Charlotte Department of Transportation

Memorandum

Subject: Rezoning Petition 08-157: Located on the south side of Central Avenue
between Crystal Road and Cyrus Drive

CENTRAL AVENUE

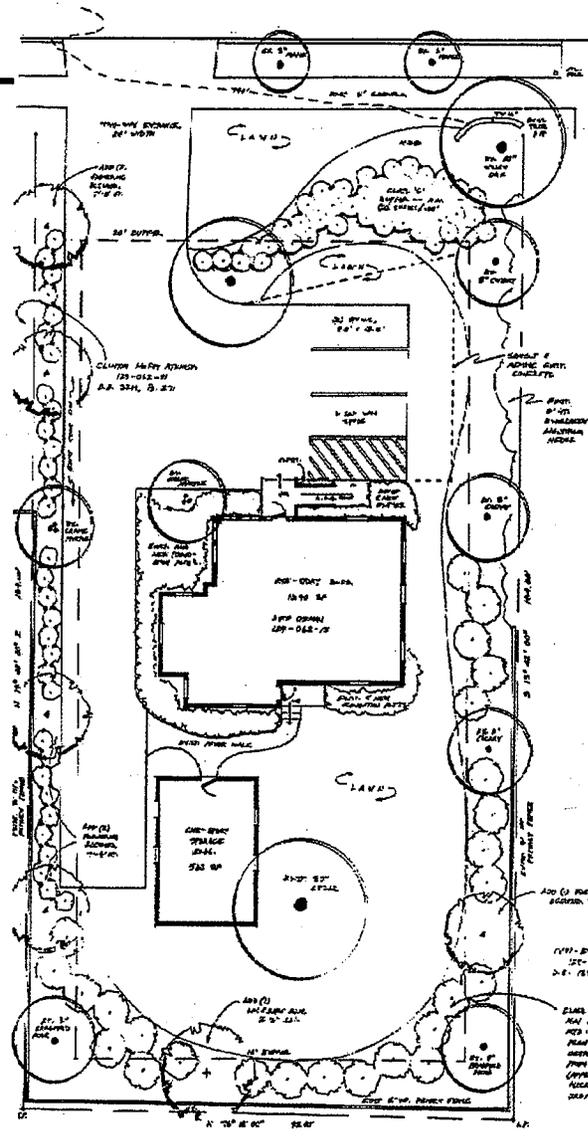
1. Parking calculations are required to confirm that adequate parking is provided.
2. The setback on Central Avenue is 14 feet and includes an 8-foot planting strip and 6-foot sidewalk. This zoning district requires the setback to be measured from the back of either the existing or a future curb line. Bike lanes have been identified as being needed on Central Avenue. For this reason the future curb line will be located 4 feet from the existing curb line and the setback located 18 feet from the back of the existing curb line. Although the future curb line is not required to be constructed at this time, the sidewalk needs to be constructed in its future location resulting in a wider (12-foot) planting strip. Any street trees that are planted are to be located 4 feet from the front edge of the new sidewalk so that they will be in the middle of the future 8-foot planting strip.

Central Avenue is a major thoroughfare inside Route 4 requiring a minimum of 80 feet of right-of-way. The developer/petitioner should convey right-of-way in fee simple title to meet this requirement, measuring 40 feet from the centerline of the roadway.

Any proposed/modified driveway connection(s) will require a driveway permit(s) to be submitted to CDOT for review and approval. The exact driveway location(s) and type/width of the driveway(s) will be determined by CDOT during the driveway permit process. The locations of the driveway(s) shown on the site plan are subject to change in order to align with driveway(s) on the opposite side of the street and comply with City Driveway Regulations and the City Tree Ordinance.

- Meet applicable standards in the Charlotte Land Development Standards Manual (latest revision).
- New/reconstructed driveways must be drop curb Type II-Modified driveways.
- Indicate the locations and widths of all adjacent and opposing driveways.
- Indicate typical parking module dimensions.
- Include a parking summary with figures for the numbers of parking spaces required and provided.
